RE: ENGINEER CERTIFICATION FOR GOLDEN TARGET STORAGE (F20-D25)
CERTIFICATION STATEMENT DATED 7/1/96.

RE: REVISION TO GOLDEN TARGET STORAGE OUTFALL CONCEPT (F20-D25)
ENGINEER'S STAMP DATED 3/4/96.

RE: DRAINAGE PLAN FOR GOLDEN TARGET STORAGE (F20-D25)
ENGINEER'S STAMP DATED 9/19/95.

RE: RESPONSE TO YOUR COMMENTS DATED SEPTEMBER 28, 1995, FOR
GOLDEN TARGET SELF STORAGE

SHEET NUMBER
D-1

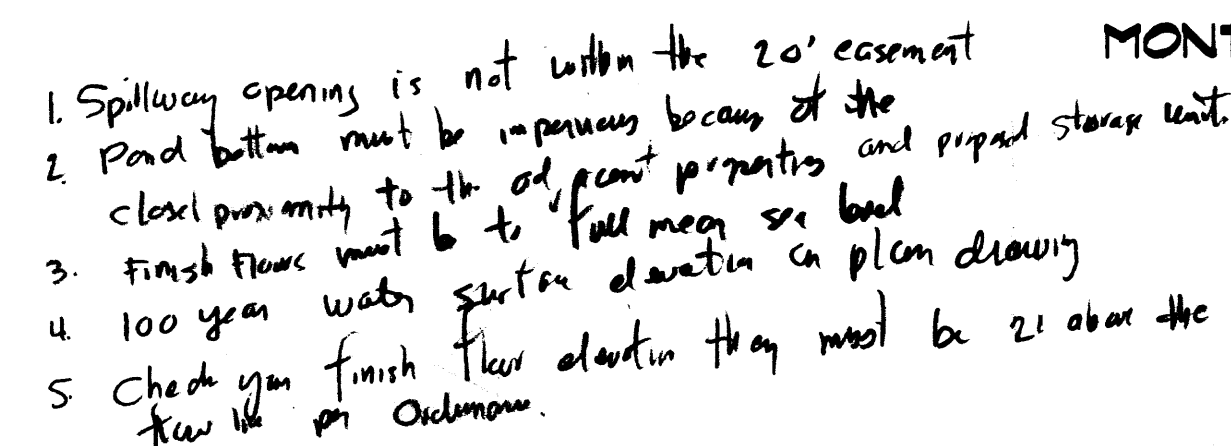
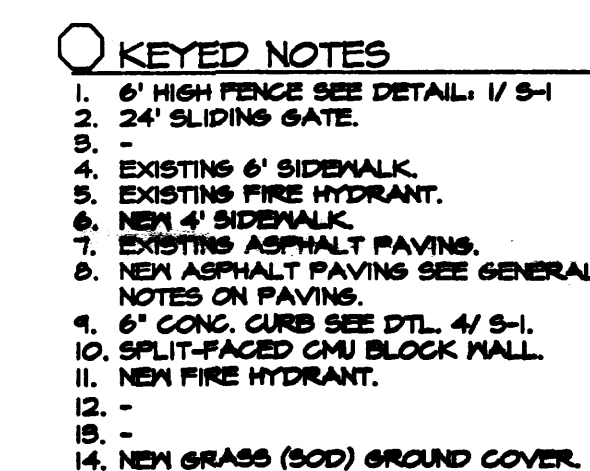
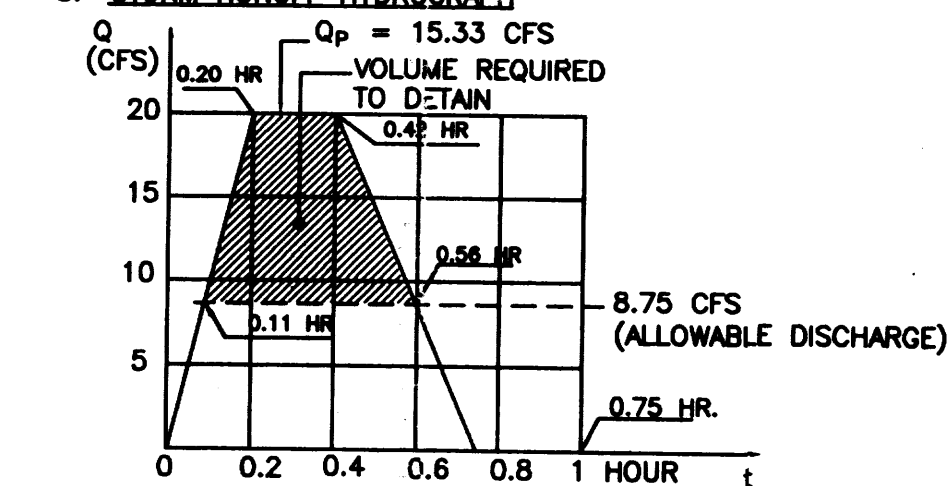
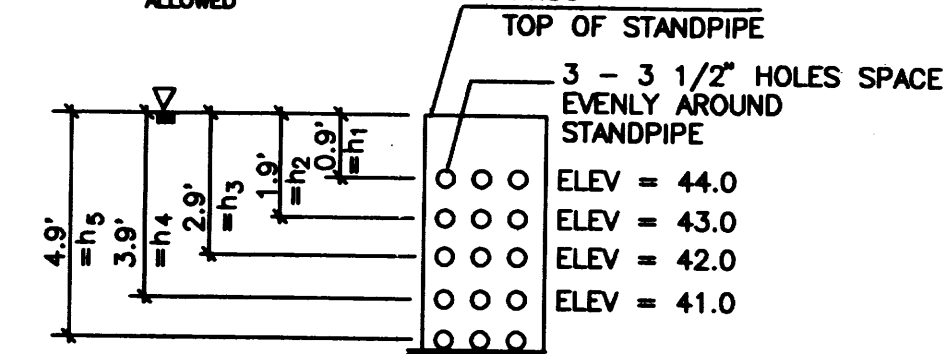
1. Spillway opening is not within the 20' easement.
2. Pond bottom must be impervious because of the close proximity to the adjacent properties and the proposed storage unit.
3. Finish floors must be to full mean sea level designation.
4. 100-year water surface elevation on the plan drawing.
5. Location & direction of roof drains.
6. Check your finish floor elevations, they must be 2' above the flow line per Ordinance.
7. T.B.M. location & elevation must be permanently marked.
8. Concurrence from Glenn Jurgensen of Arroyo Maintenance for connection onto the existing man hole in case they need the opening for maintenance purposes.

1. The spillway opening has been resized to fit the 20' easement resulting in a net opening of a 9' width to convey the Q100.
2. A 4" thick concrete slab has been added to the pond bottom.

3. Due to the number of finish floor elevations on this plan, I would ask to allow a note on the legend which states, "add 5400 feet to all elevations on this plan in order to establish full mean sea level designation." The office building is now shown to a full mean sea level designation.

4. The 100 year water surface elevation is zone AO (Depth 1 foot) and is now shown on the plan per the F.I.R.M. Map.
5. Roof slope directions have been added to all storage buildings along the exterior property line, which show flows have to be drained into this site. A note has been added to the legend as well. No roof directions have been added to the interior storage buildings since all flow arrives at the same outfall, also this will allow the manufacturer some flexibility when fabricating the roof systems.

6. The office building has been raised to be two feet above the flowline of Montgomery Boulevard. We would ask that the storage buildings be given a variance from this requirement since they will not be occupied by individuals. Also, the existing waterblock that was built and designed by the existing Golden Corral Restaurant will be maintained from Montgomery Boulevard.

7. The permanent benchmark is 150 feet east of the Southeast Corner of this site. The permanent benchmark location is now shown on the plan. The contractor is able to set up on the Southeast corner and backside the permanent benchmark and will be able to establish elevations on site. We would ask that a T.B.M. not be required due to the proximity of the permanent B.M.

8. I have met with Glen Jurgenson, since this system between the manhole the Golden Corral Restaurant is privately maintained, he has no objection. Glen did give me some input on the standpipe details which I am incorporating into the design.
